Dear Secretary of State,

As an Interested Party (IP) we are grateful for the opportunity to provide comment by written response to the SoS BEIS’s letter dated 11<sup>th</sup> November 2021 (Reference A) for the re-determination of the Norfolk Vanguard windfarm project. We note the deadline for IPs to respond was subsequently extended to 23:59hrs on Friday 19<sup>th</sup> November 2021.

## **Substation Design**

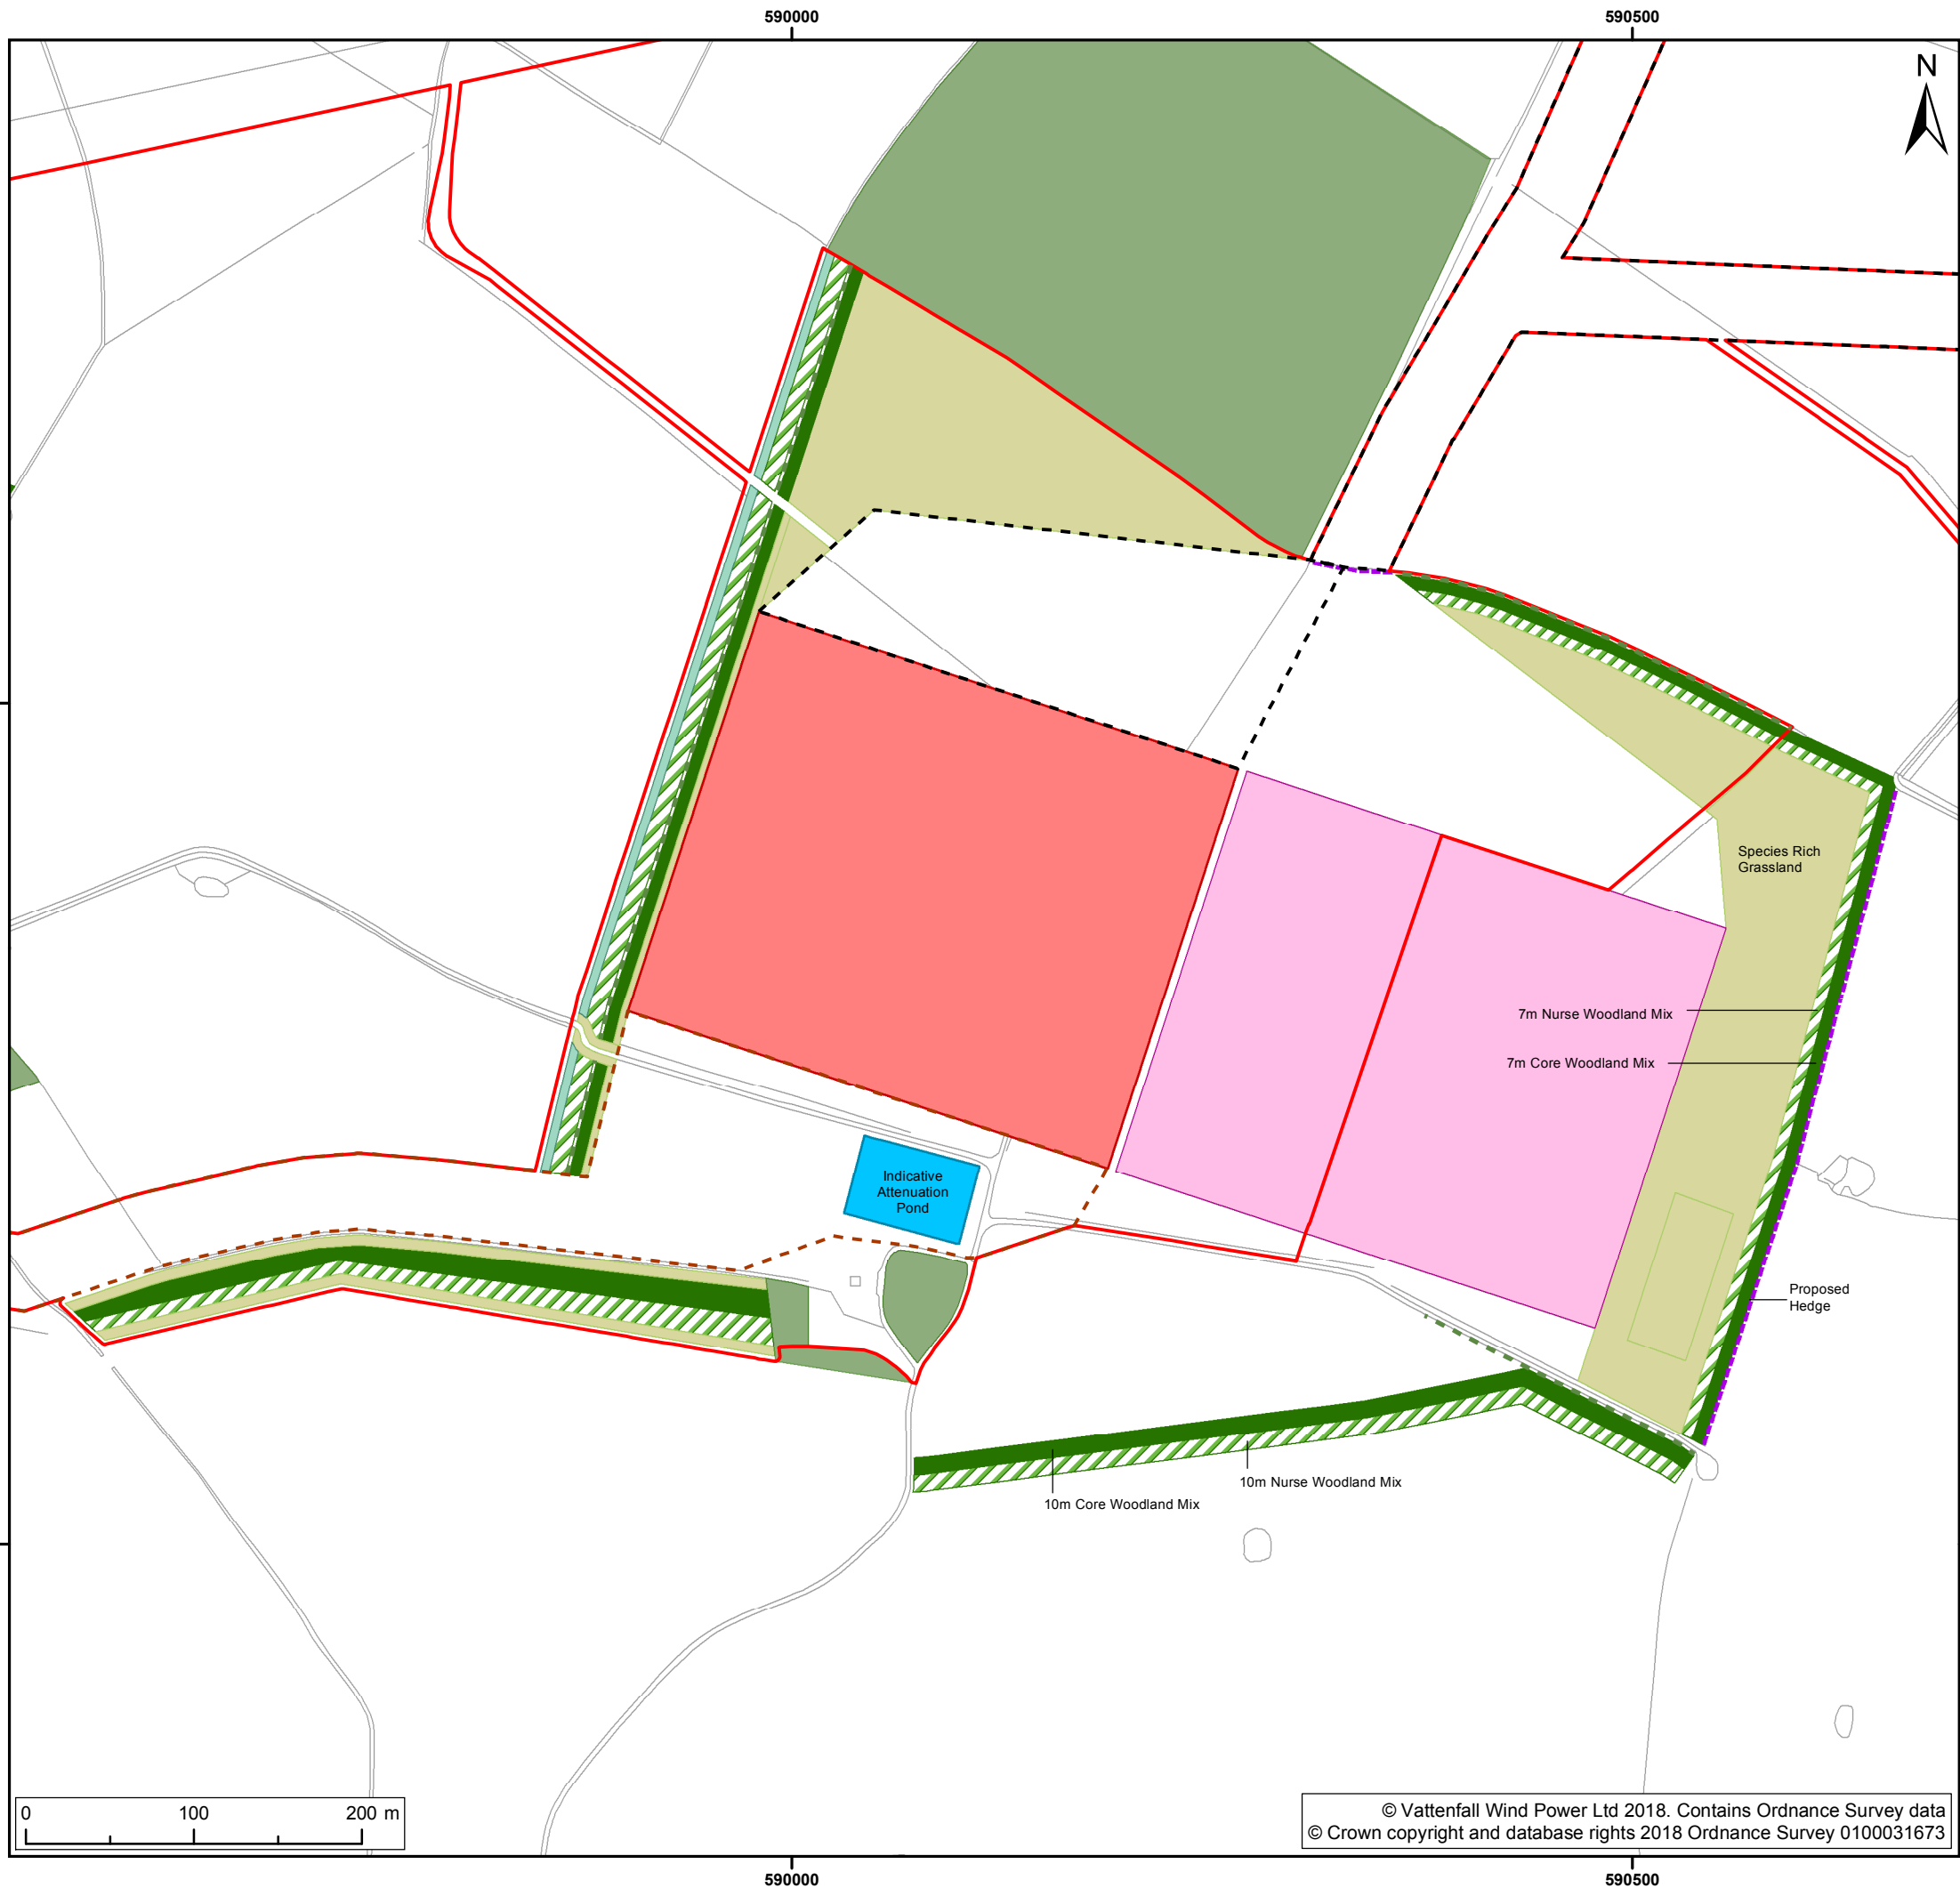
- **Mitigation Planting.** As explained previously, with the re-determination, there is no longer a year between the DCO applications for Norfolk Vanguard and Boreas. Therefore, any planting mitigation would need to be re-assessed. However, the measures would not, by any stretch of the imagination, be sufficient to mask the complex irrespective of when planting commenced.

Irrespective of the ‘palette’ of species planted, with a total operational use of just 25 years, the planted trees will have little visual impact of any consequence.
